Planning Application Reference No.: 3/2026/0110

Address of Development: The Old Rectory
Gisburn Rd
Bolton by Bowland

Proposed Ground Floor Plan and South Elevation

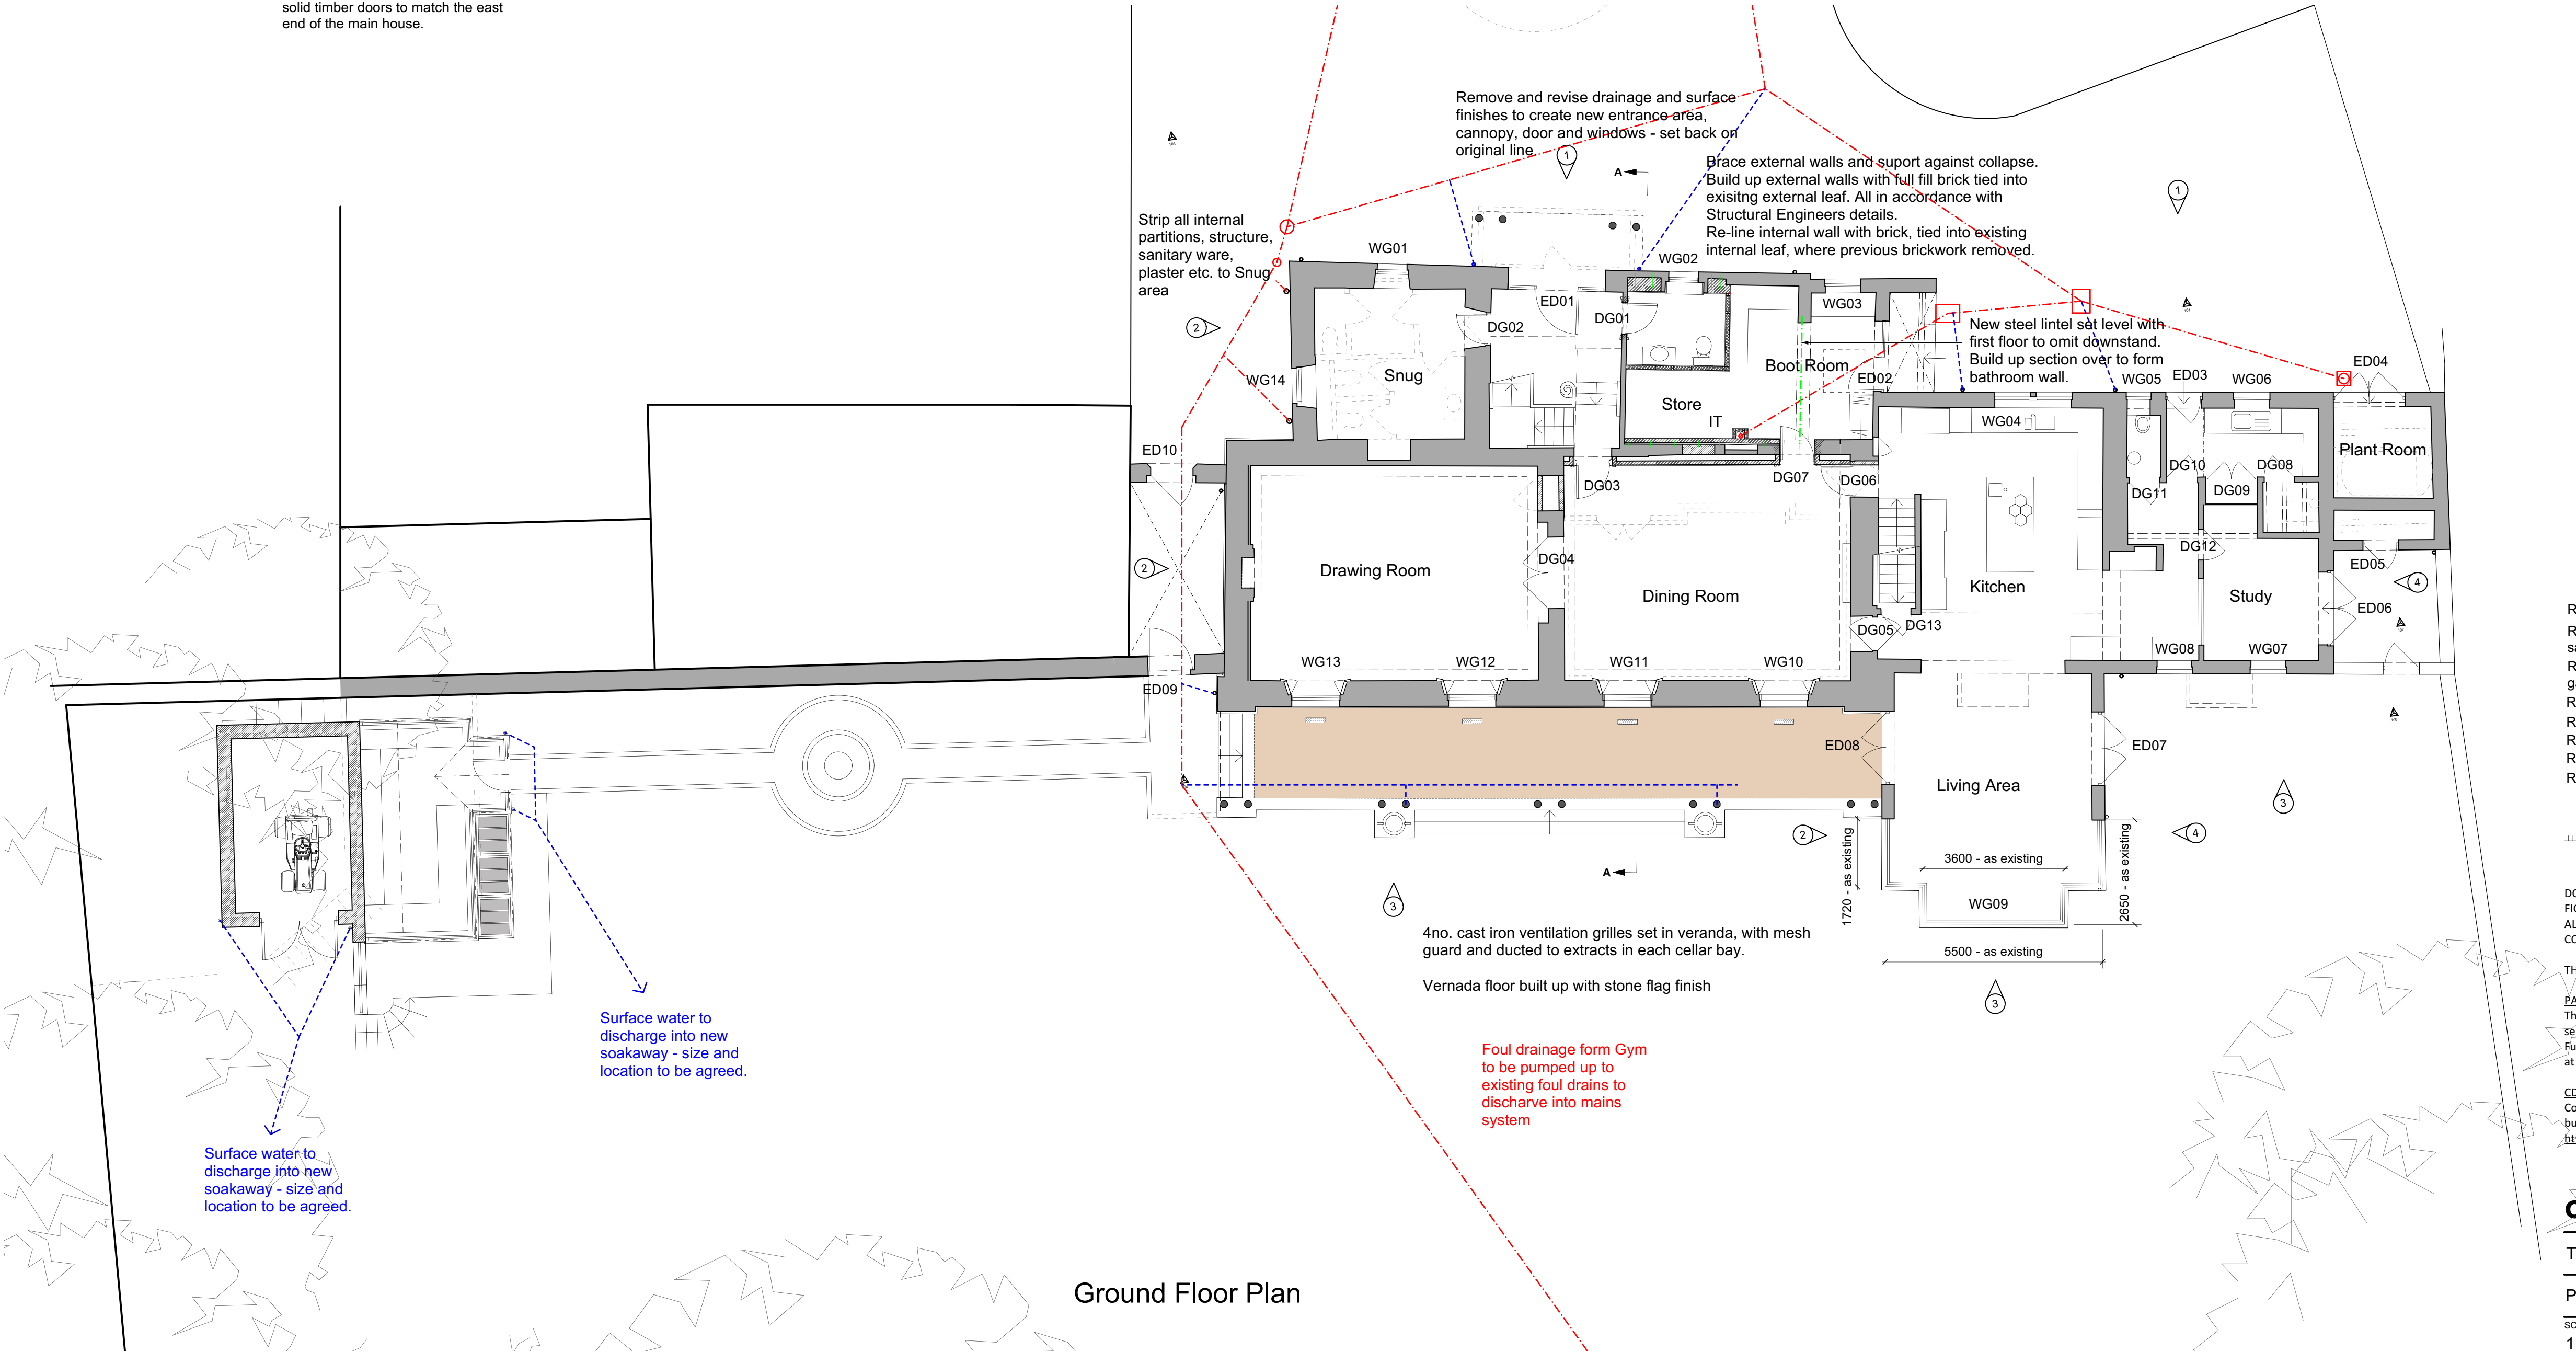
The current position of the greenhouse and the elevated position and ground level difference would mean a direct loss of privacy [REDACTED]
Therefore I asked if you would review or would look at this more closely and consider a different position
[REDACTED]
